From: Nolan, Chris <Chris.Nolan@lancashire.gov.uk>
Sent: 08 November 2017 14:23
To: John Macholc; planning
Cc: LHS Customer Service
Subject: D3.2017.0996/ 0997 - Stanworth House York Street Clitheroe

Planning Application No: 3/2017/0997 and 3/2017/0996

Proposal: Refurbishment of existing dwelling, demolition of existing workshop and conservatory and erection of single and two-storey extensions to side and rear of dwelling. Erection of new freestanding workshop.

Location: Stanworth House York Street Clitheroe BB7 2DH

NEW DRIVE LAYOUT

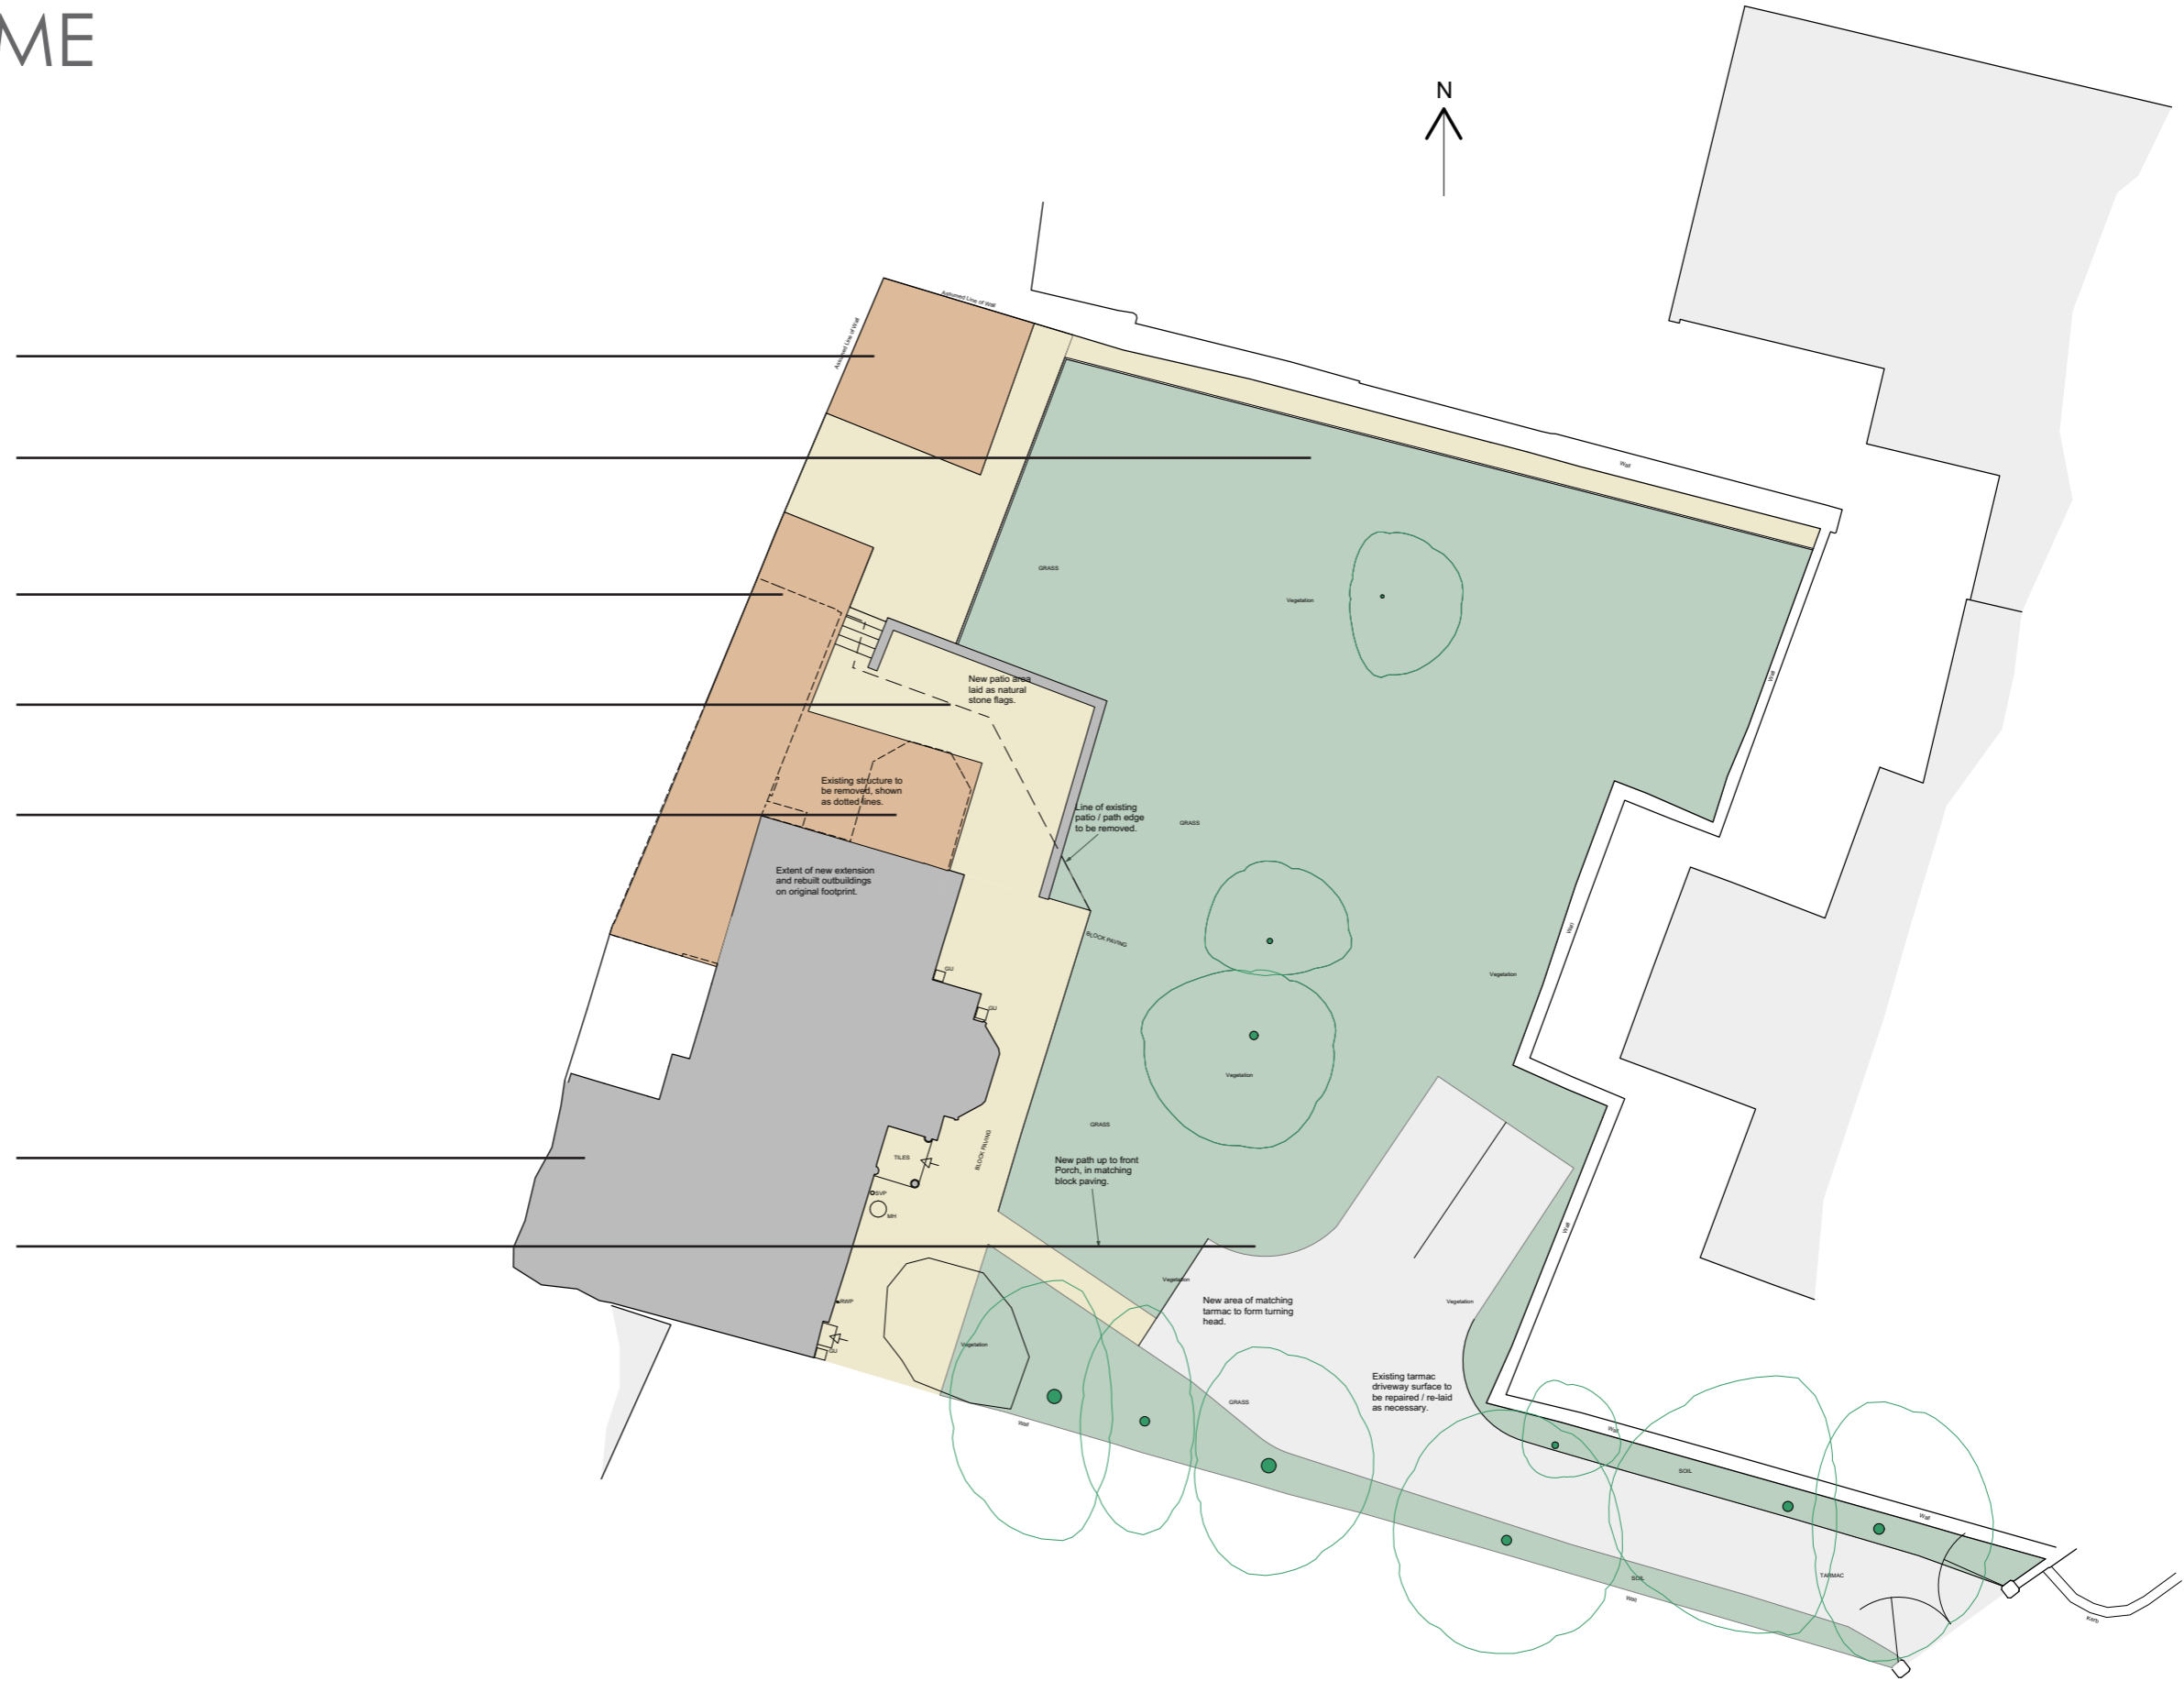
Scaling the plans the drive offers two parking places plus a provision to turn the vehicles so that access to the property will be undertaken using forward gears. It should be noted that the additional bed room would indicate that the present proposal is not sufficient to meet the base line parking requirements as included in the Joint Lancashire Structure Plan. For a property with four or more bedrooms I would require parking within the curtilage of the property for a minimum of three vehicles. The access to Stanworth House from York Street is of minimal width and on to a busy road in the centre of Clitheroe and for this reason I would be requiring that that the turning facility is retained to ensure that vehicles continue to enter and leave the property using forward gears.

I will be requiring a new plan indicating parking for three vehicles along with facilities to allow the necessary turning. Any off highway parking bay should be 2.4m X 4.8m and ideally the bays should allow independent use of vehicles. That is it should not be necessary to move one vehicle to allow a second to be used. Once I am satisfied that the site will provide sufficient parking for the three bedroom dwelling then I would not raise objections on highway grounds.
